Description: New fascia sign and projecting sign

Location: 23 Hall Place
Spalding

Amendment: Reversed colours & type of illumination
Details received 21 November 2002

Lunn Poly, 23 Hall Place, Spalding, PE11 1SQ
Application No. H16/0932/02

Project: Lunn Poly World of TUJ
Address: Swindon
Account Manager: Mike Spence
Designer: Graham Niles
Date: 18 November 2002
Status: NTS
Revision: C

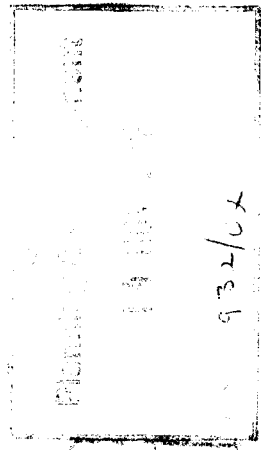
Following your recent telephone conversation with my colleague Simon Stokes, please find enclosed revised plans to be submitted with the above application for advertisement consent. Following your comments we have reversed the colours, changed to halo letters on retained timber fascia and removed the projecting sign.
